CITY OF ALBUQUERQUE

March 11, 2025

RE: 2500 Phoenix Ave. NE
Menaul & Vasser
Grading & Drainage Plan
Engineer's Stamp Date: 01/03/2025
Hydrology File: H16D156
ABQ-PLAN File: HYDR-2025-00060

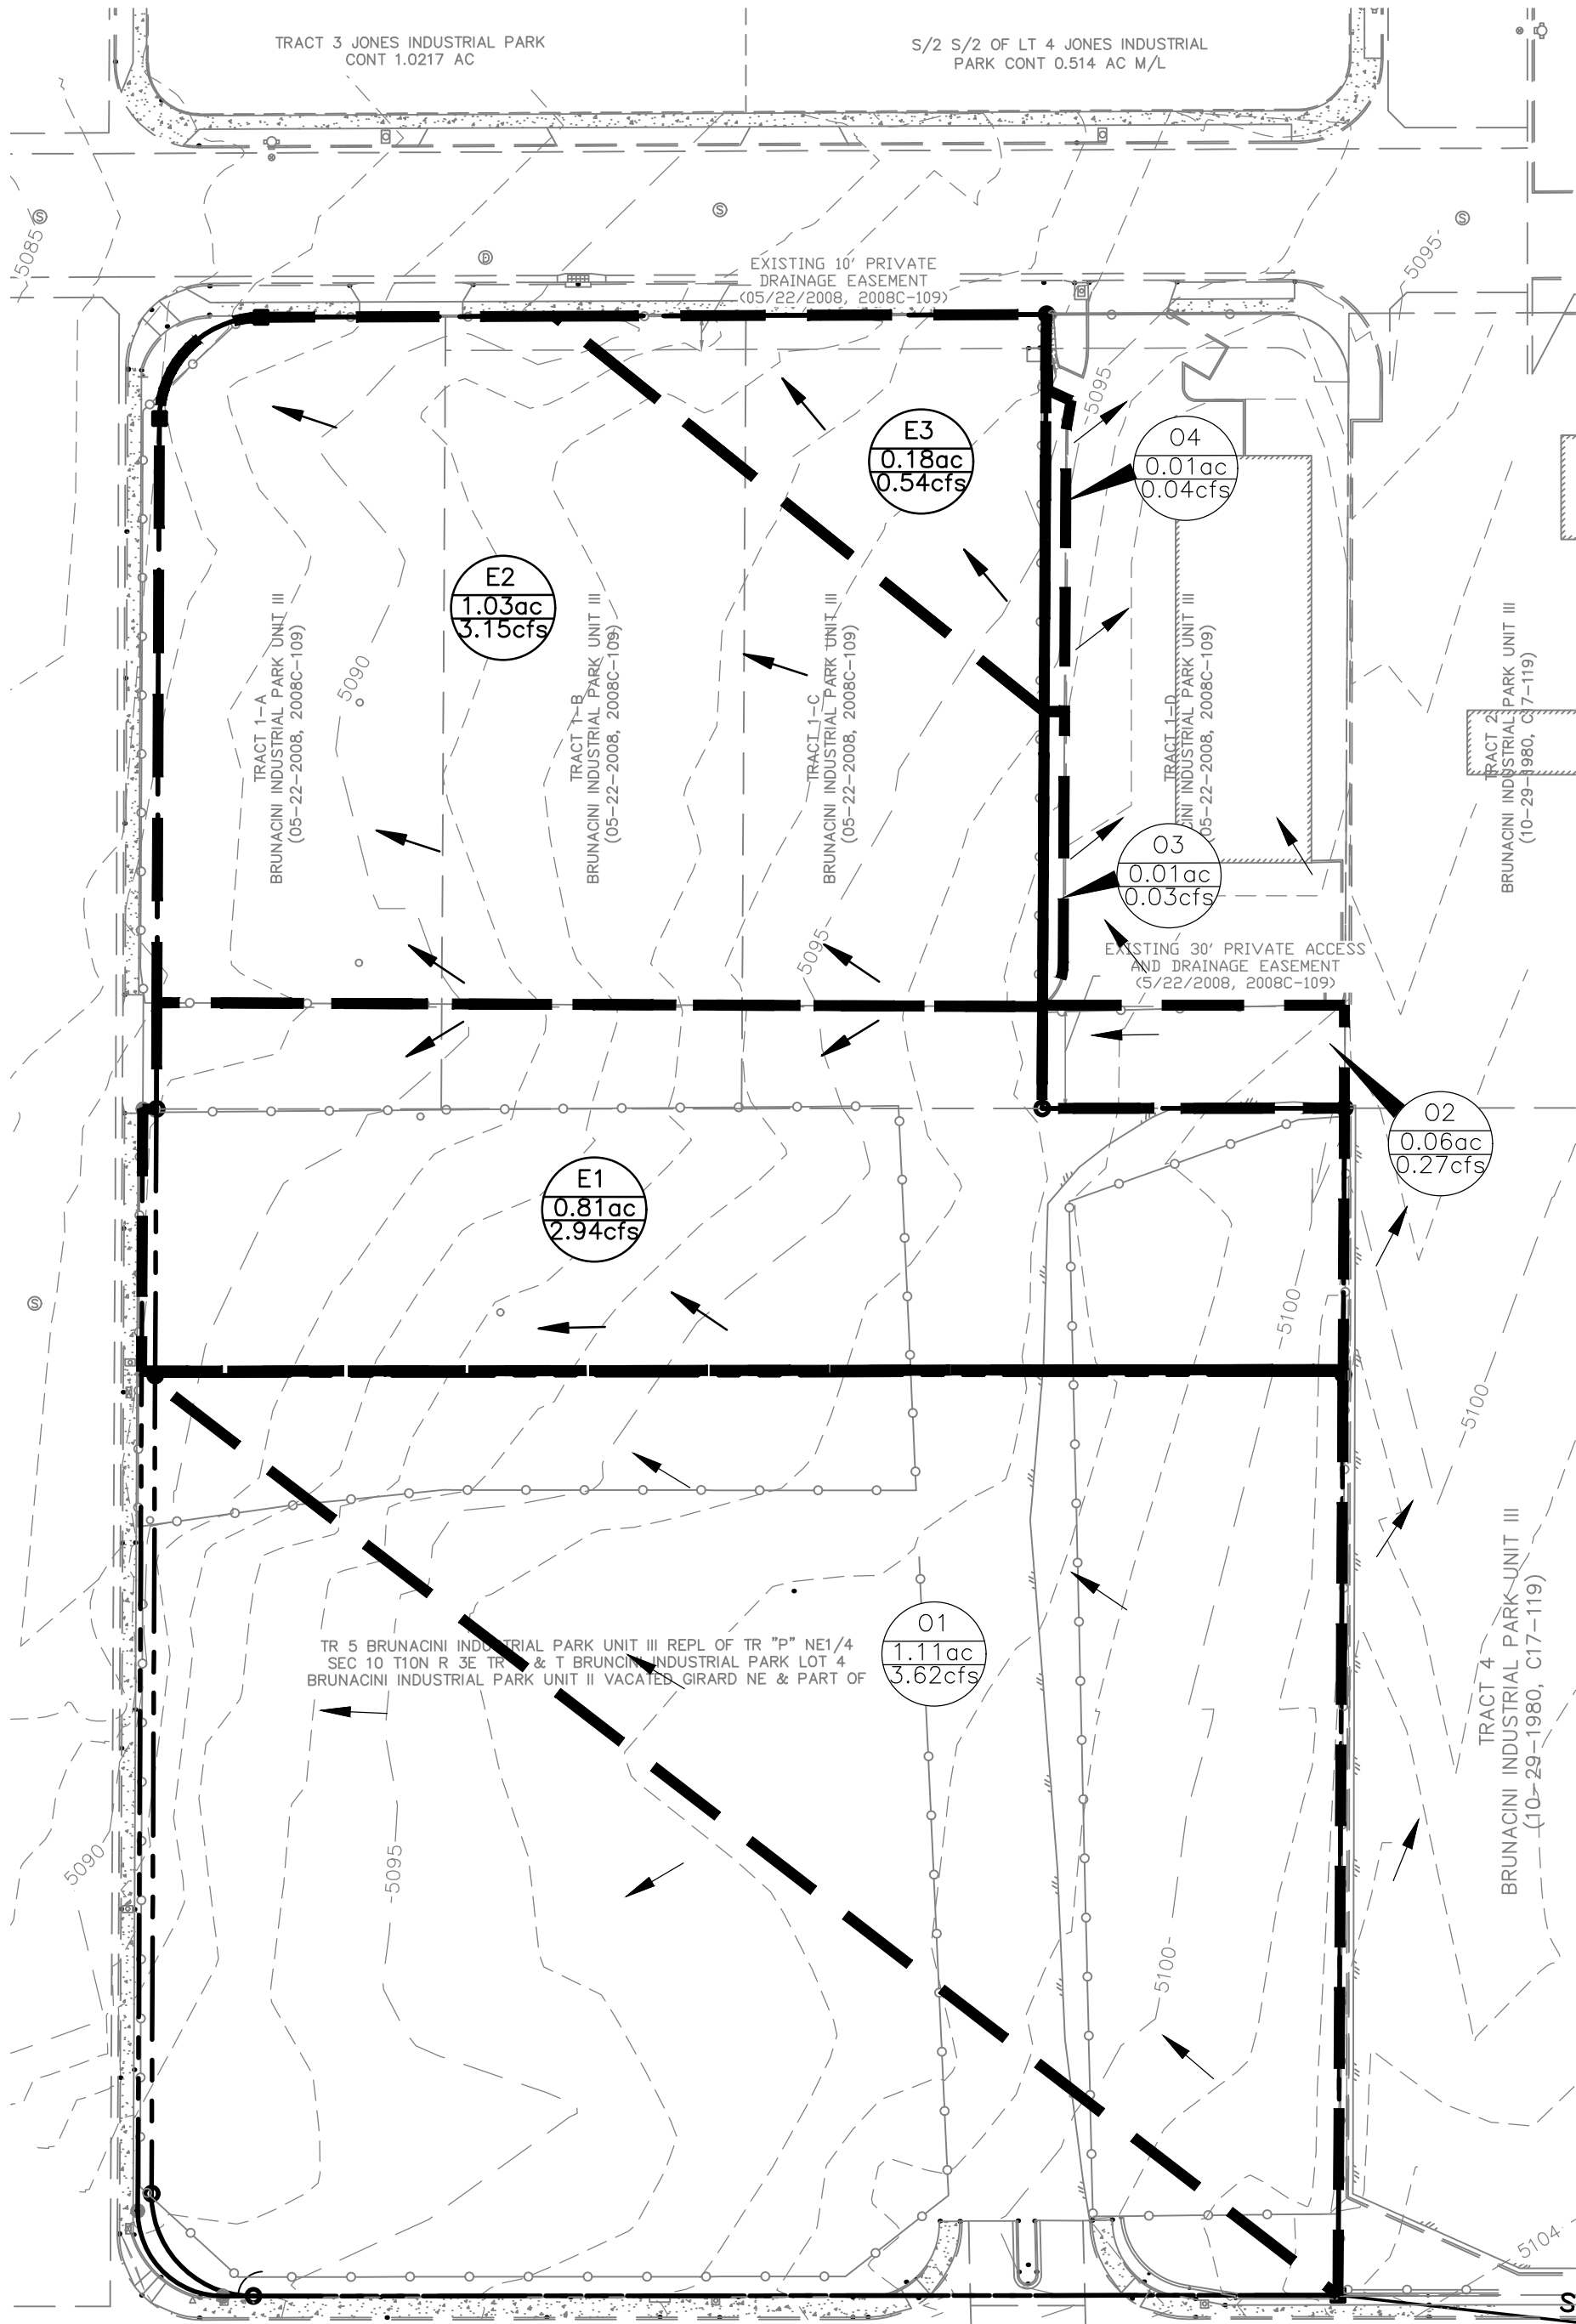
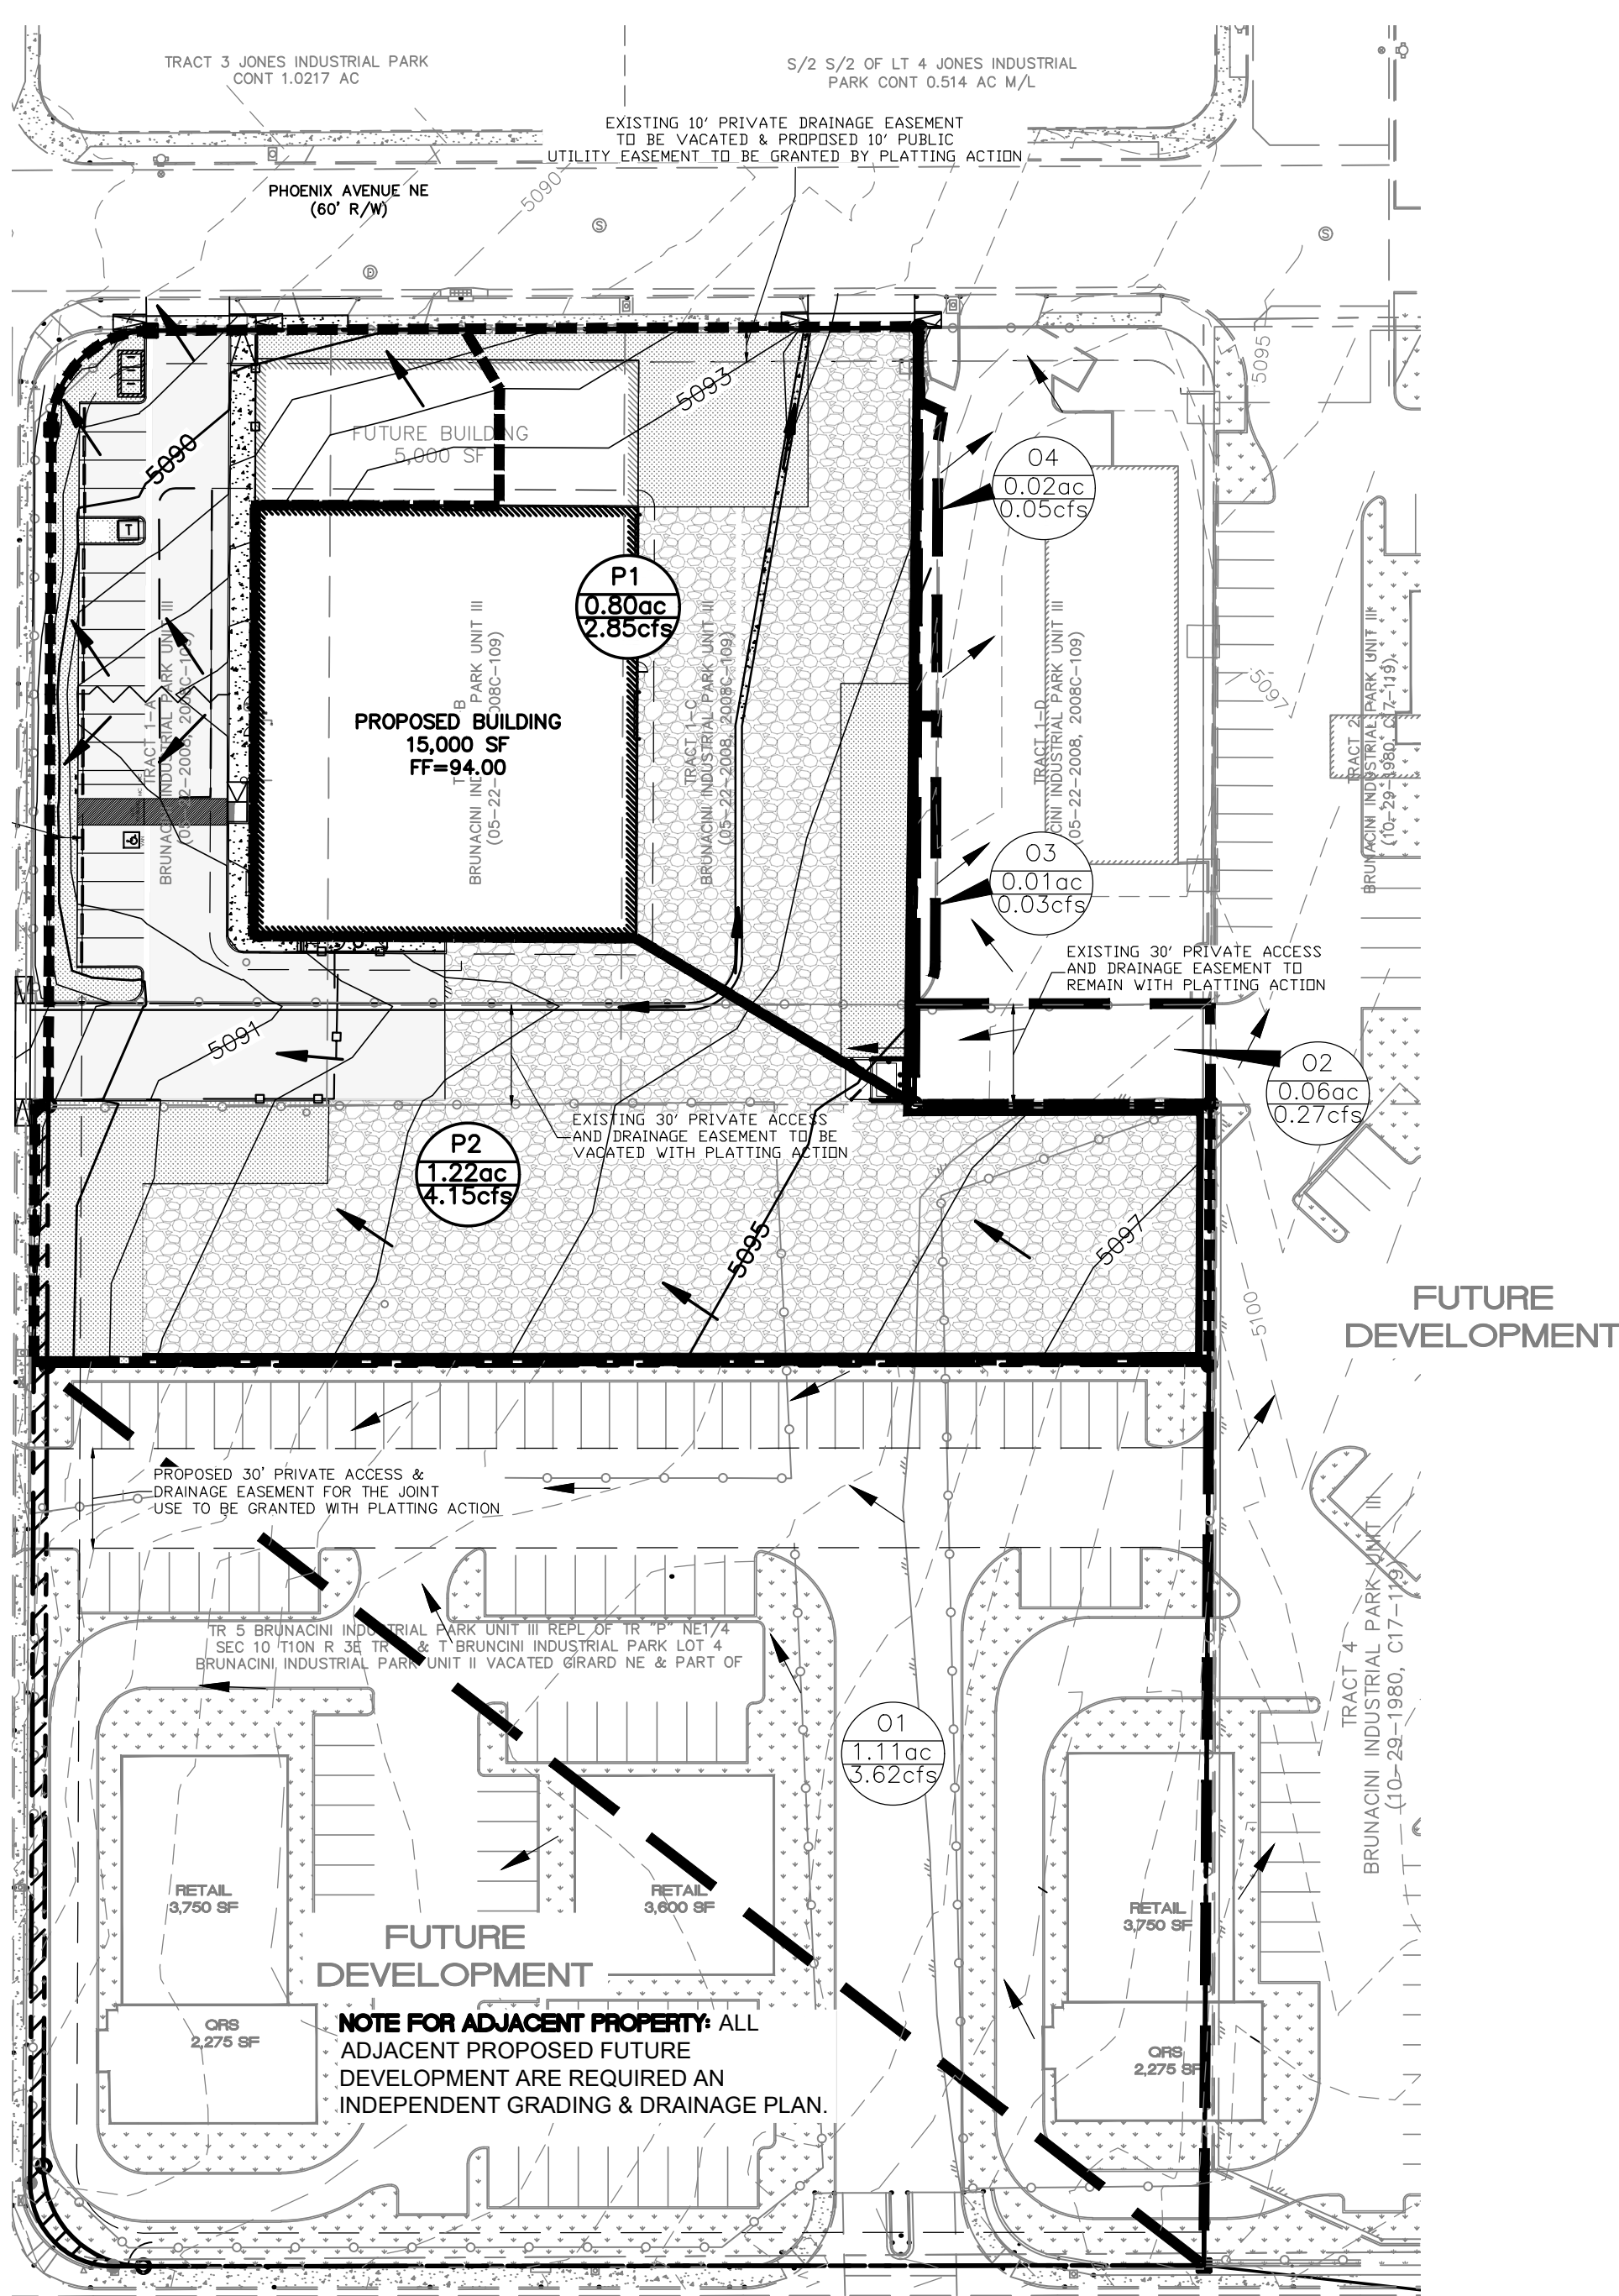
1. Revisions to Grading & Drainage Plans require a current or appropriate Engineer's stamp and date.
2. All drainage and access easements that are proposed to be vacated or abandoned per the Response to Comment letter dated 12/18/2024 should be completed and recordation documentation be provided on Sheet C2.1. Otherwise, said easements to remain should be shown where appropriate.

4. Independent Grading & Drainage Plans are required for All adjacent proposed future developments, with a Note being included on Sheet C2.1 indicating such.
